Your ref:	Hospital of St. John and St. ...	<b>Please reply to:</b>	<b>Fraser Fikrie</b>
Our ref:	23/07223/FULL	Tel No:	0753424 7967
		Fee Queries:	0207 641 6500;
		Email:	planningreception@westminster.gov.uk;
Mr Gavin Curwen Edgeplan Ltd Causeway House, 13 The Causeway Teddington TW11 0JR United Kingdom		<b>Incomplete Applications</b> Town Planning & Building Control City of Westminster PO Box 732 Redhill, RH1 9FL	
			27 October 2023

**Address: Hospital, 60 Grove End Road, London, NW8 9NH,**

**Proposal: Demolition of a ramp in a conservation area, infilling of terrace wall, lower basement level by 0.7 metres and replacement of windows and doors with upvc glazing**

DRAWING TITLE:
Existing and Proposed NW Elevation

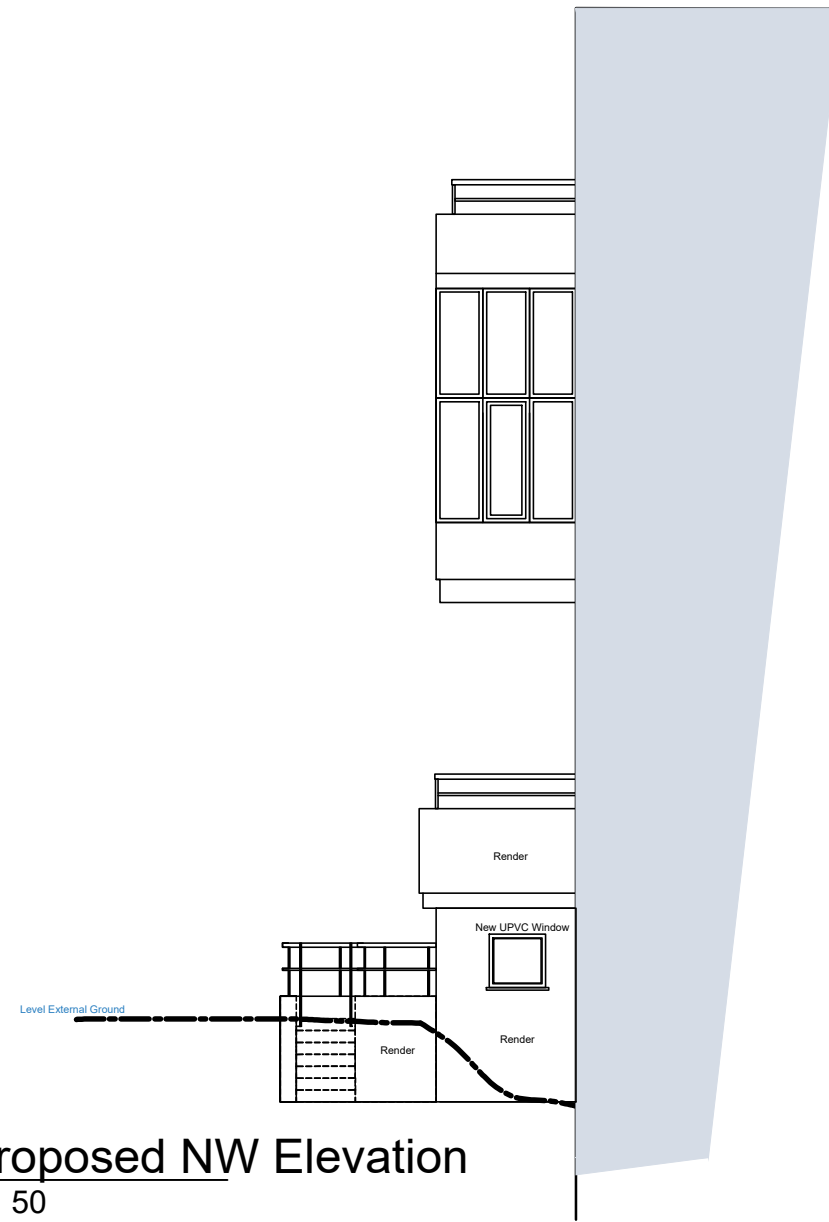
- 1 Some or all of the drawings submitted with your application do not include a scale bar, please amend the drawings to ensure all drawings include a scale bar.
- 2 Please provide a sustainable design statement.

3 here are no detailed drawings of the windows, Therefore we cannot properly consider the impact of the alterations in heritage asset terms.

- Please provide existing and proposed detailed drawings (section through) of the windows.
